Re: Harborview Heights – Technical Review 2  
SP23-007

After reviewing the application materials for the above referenced proposal, the following technical review comments are provided:

DATE: 5-Aug-24
JOB NO: 2023 052
DRAWN: SH
CHECKED: EN
REVISION:
SITE/UTILITY PLAN
SHEET: SP-01

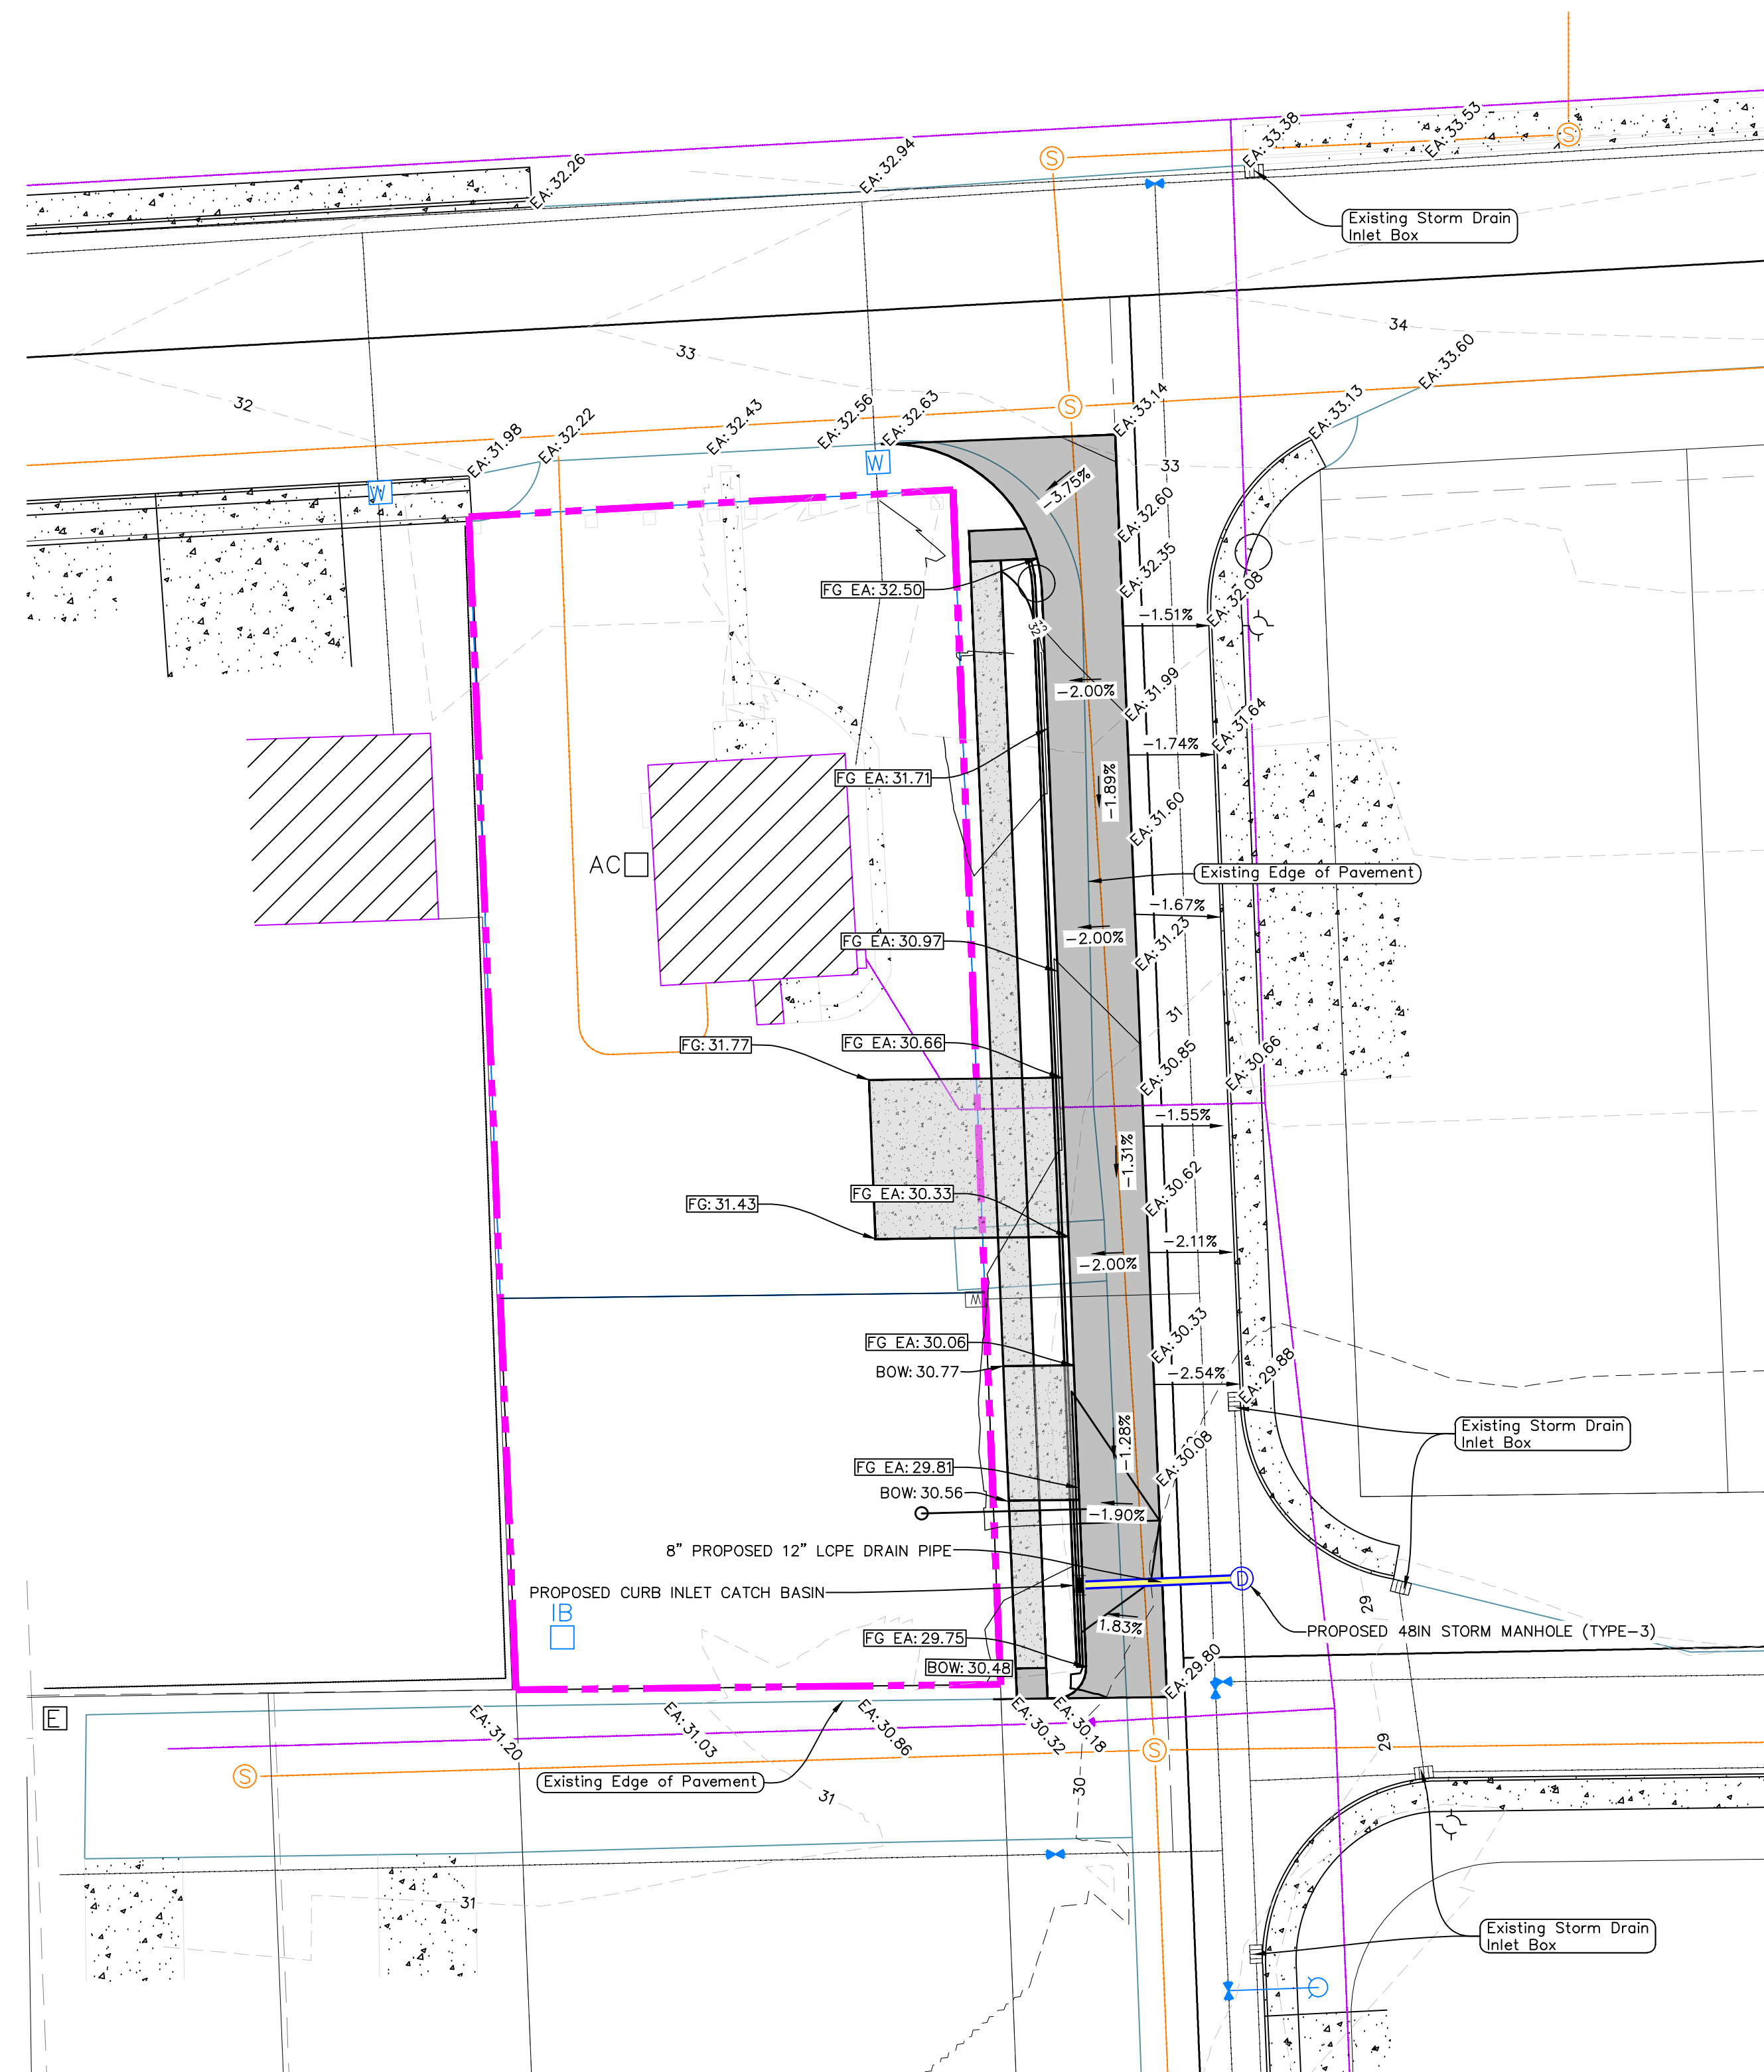
6. On the supplied plans it shows a 4 inch side sewer to the new lot, in the civil submittal the City will require a 6 inch service from the main to the lot.
7. The plat map and the plans will need to show a 10-foot utilities easement within the property where the lots abut City right-of-way.
8. All civil construction plan submittals are to be completed through our online permit portal at <https://permits.marysvillewa.gov/PermitApplication/confirmation.aspx> following the link: <https://permits.marysvillewa.gov/PermitApplication/confirmation.aspx> Once the submittal is complete, please email the permit tech's at [msvlpermits@marysvillewa.gov](mailto:msvlpermits@marysvillewa.gov)
- a. Review timing:
- i. First review = 5 weeks
  - ii. Second review = 3 weeks
  - iii. Third review = 3 weeks
  - iv. Subsequent reviews repeat the above schedule.

LS-01

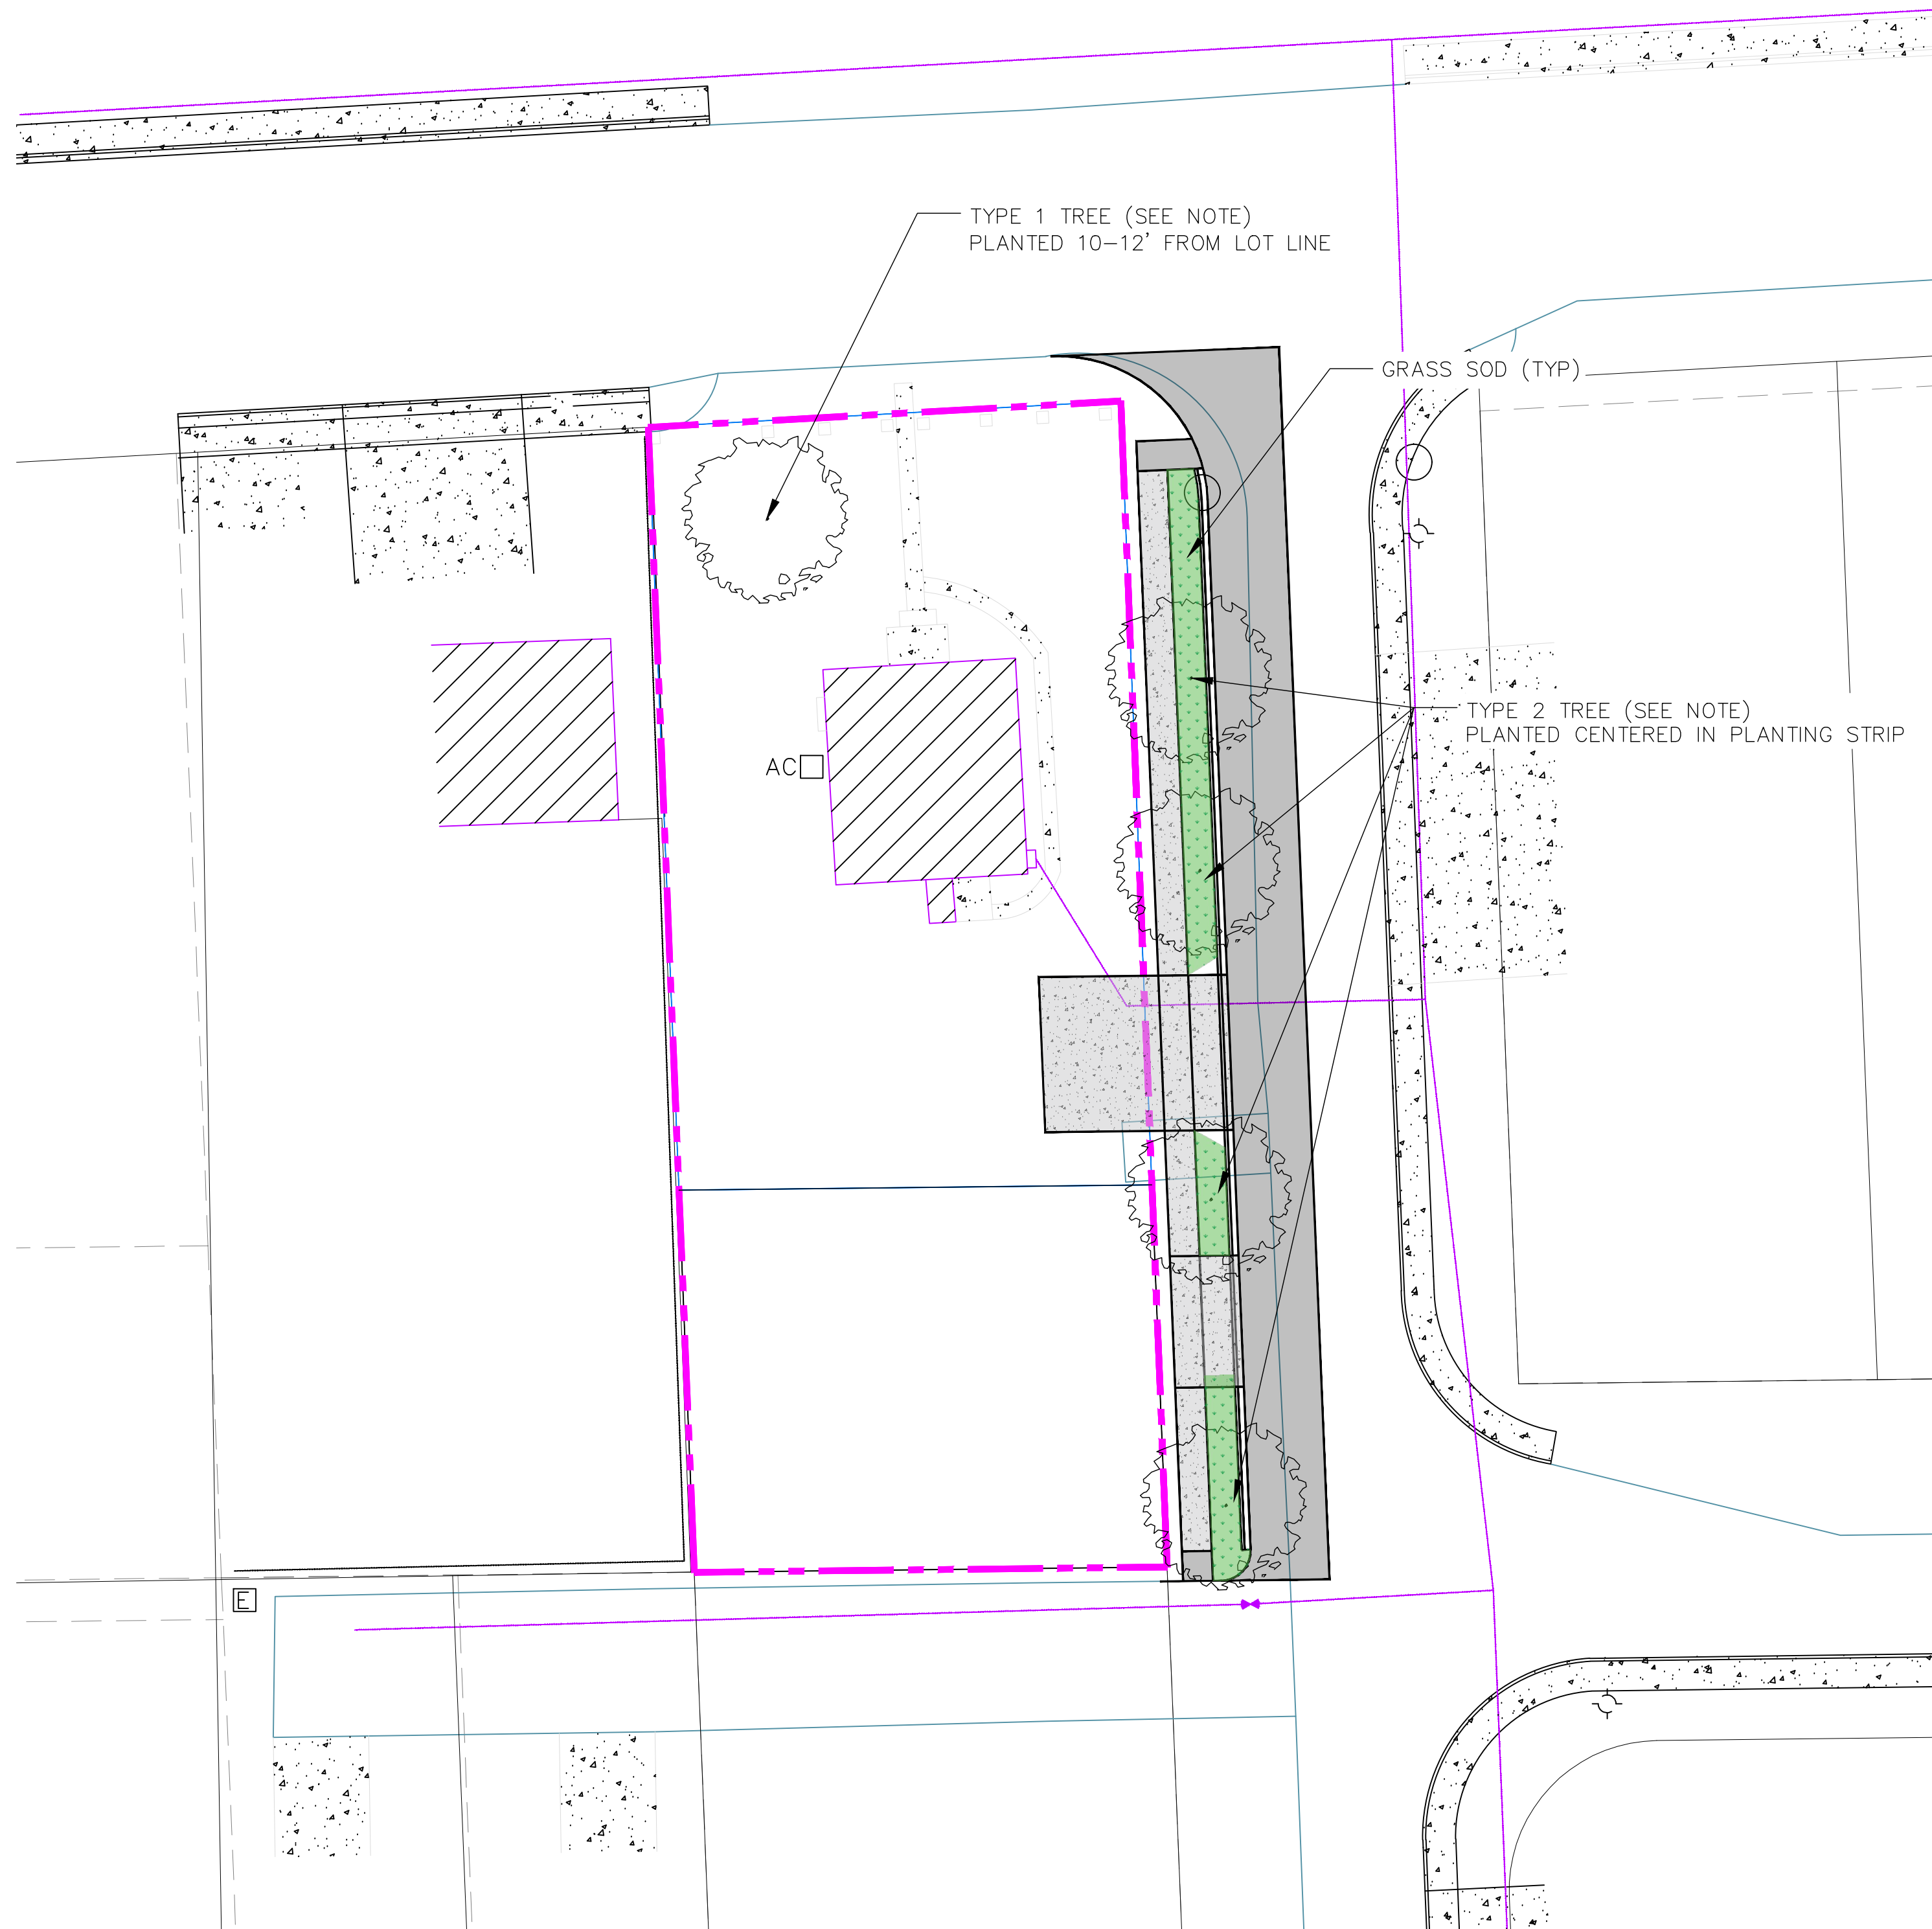
3. **TR1 Comment:** The applicant shall be required to submit a preliminary landscaping plan that includes the following:

a. Provide a detailed planting plan of the proposed bioswales along 52nd Ave NE.

**TR2 Comment:** A detailed planting place of the proposed bioswales has not been provided.

**TR1 Response:** A landscaping plan is included with the Civil Plans.
